CITY OF ALBUQUERQUE
PUBLIC WORKS DEPARTMENT
UTILITY DEVELOPMENT DIVISION/HYDROLOGY SECTION

PRE-DESIGN CONFERENCE

DRAINAGE FILE/ZONE ATLAS PAGE NO.: K-14 DATE: 7/27/90
EPC NO.: _____ DRB NO.: _____ ZONE: _____
SUBJECT: HIGHLAND MEDICAL STORAGE AREA
STREET ADDRESS: CENTRAL / BROADWAY
LEGAL DESCRIPTION: Lot 3 & 4, Block 9, HUNING, HIGHLAND ADDITION

RE: GRADING/PAVING PLAN FOR HIGHLAND MEDICAL
(K-14/D48) ENGINEER'S STAMP DATED JULY 30, 1990

GRADING AND DRAINAGE PLAN

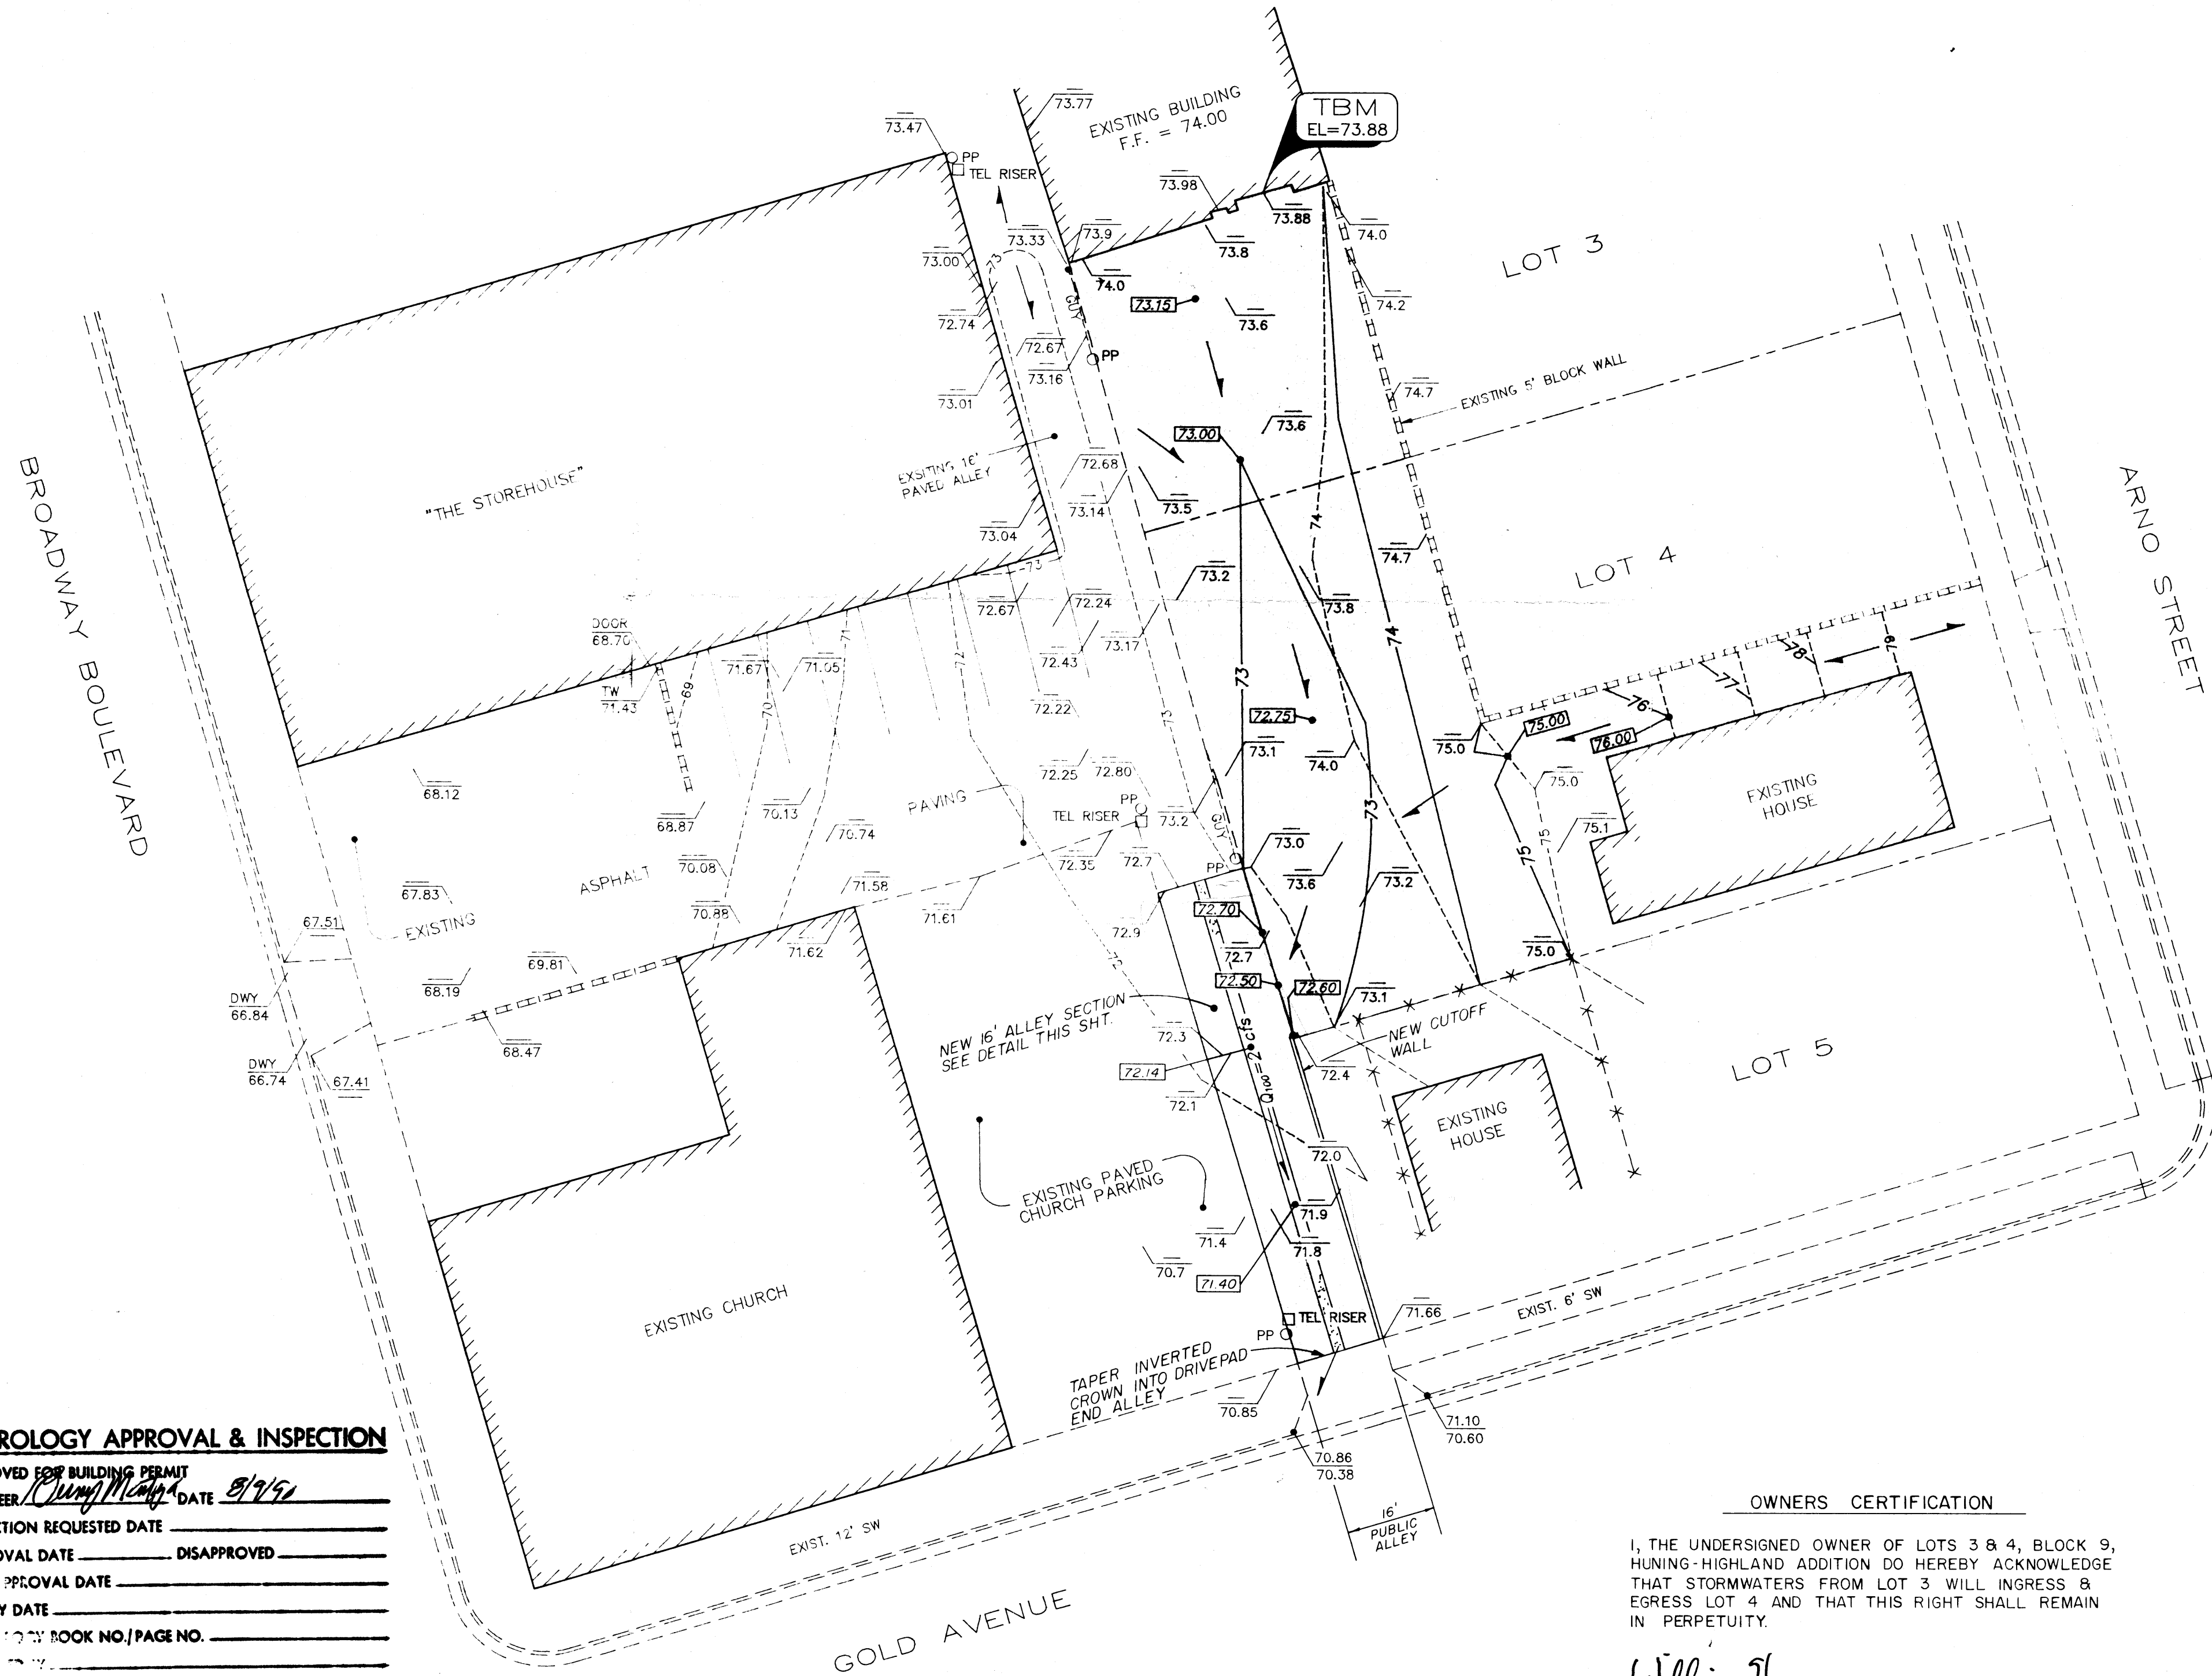
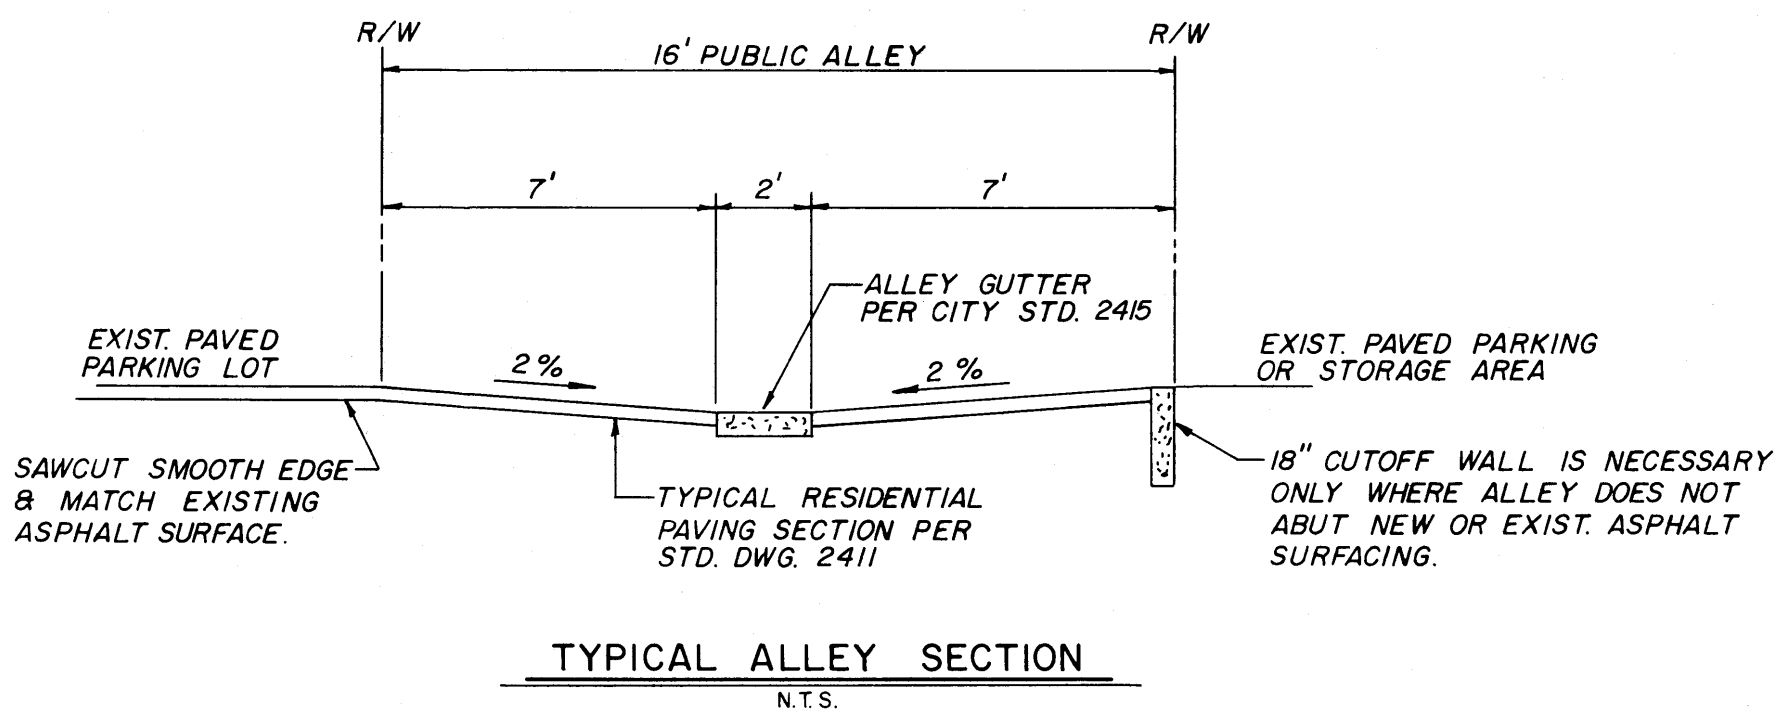
- 1.) PAVING OF Lot 3 & 4 to FREE DISCHARGE
THROUGH ALLEY & INTO GOLD AVENUE
- 2.) Will IMPROVE ALLEY SECTION TO CONVEY
Flows TO GOLD AVENUE, Flows NOT ALLOWED
TO SHEETFLOW INTO CHURCH PROPERTY
- 3.) No WORK ORDER DRAWINGS REQUIRED FOR ALLEY
IF Engineer Will Obtain SIGNATURE & FROM
TRANSPORTATION & DRC CHAIRMAN
- 4.) No EASEMENT REQUIRED IF THE LOTS 3 & 4
BELONG TO SAME OWNER AND OWNER ATTEST
ON PLAN THIS IS THE CASE TO ALLOW
CROSS LOT DRAINAGE.
